Planning Application Ref: R/203/21/PL

Location: Booker Hall, Station Road, Rustington, BN16 3AY

Description of works: Demolition of existing community hall and ancillary building and redevelopment of the site to provide a new community hall with supporting functions and office accommodation within a new 1.5 and 2 storey building with associated car parking area and landscaping

Mark Warwick
Tree Officer / Parks and Greenspace Team

Tree and Vegetation Management

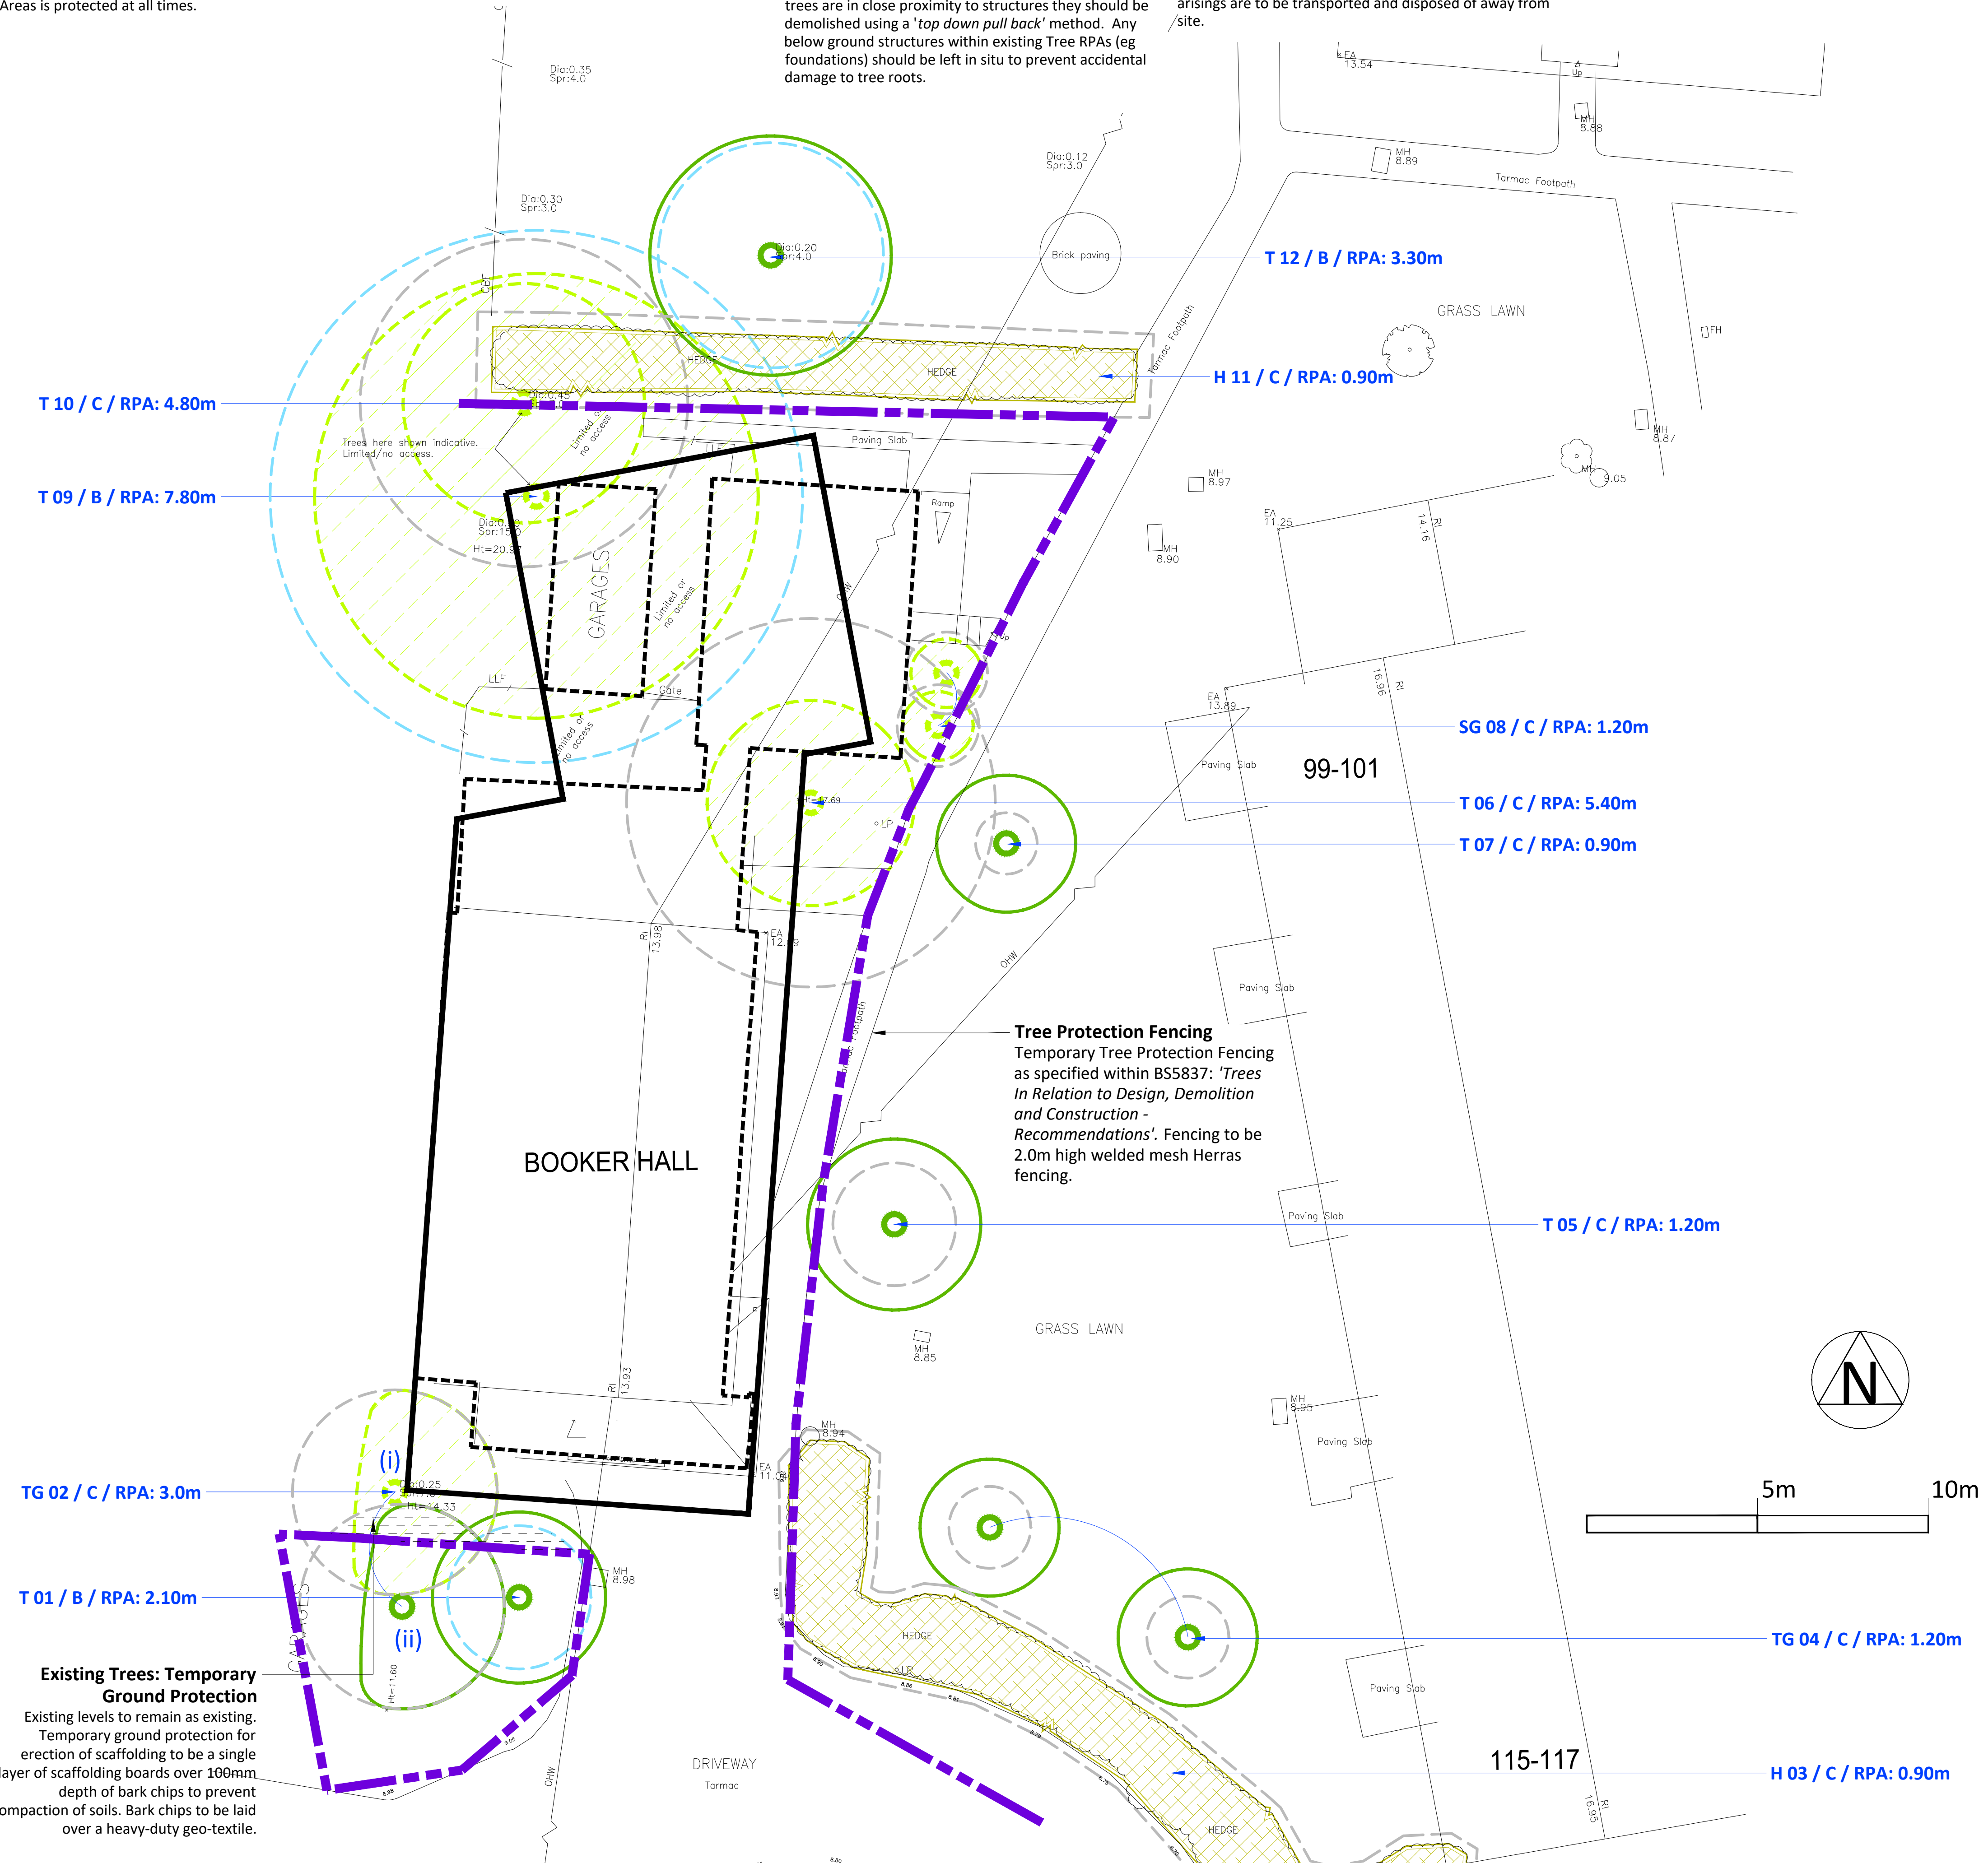
- The applicants have employed Ramsey & Co Landscape Architecture to prepare a Landscape Drawing Issue Sheet and Tree Schedule (Arboricultural Report) along with a Tree Protection Plan for this project.
- Although presentation of arboricultural information is not typical for detailed planning applications; the Tree Survey data is comprehensive and accords with the requirements of BS5837:2012. Method Statement for works in proximity to retained trees on or overlapping the site is included at the foot of the report and appropriate for the scheme. Note: this applies only to the Community Hall / Ancillary Building redevelopment proposal.

- Trees existing on the site are of relatively low public amenity value and several are probably no longer suitable for their location. No soft landscape proposal as mitigation has been submitted.

- The Community Hall / Ancillary Building redevelopment proposal is supportable in arboricultural terms, although it is disappointing not to see a soft landscape proposal (as mitigation for established tree removal) when opportunity exists at the land parcel rear of 5-7a Paddock Green. A small area set aside in the NE corner, recovered to open ground (enhanced by planting) would be ideal and act as future root protection for the off-site birch tree (TPO/R/1/18) in rear garden of 7a.

- The above issues should be addressed within a revised layout, that is especially sympathetic to a 3rd party tree of high amenity value. It should be supported by a revised Arboricultural Report and additional Tree Protection Plan, as well as a soft landscape proposal for the land parcel rear of 5-7a Paddock Green.
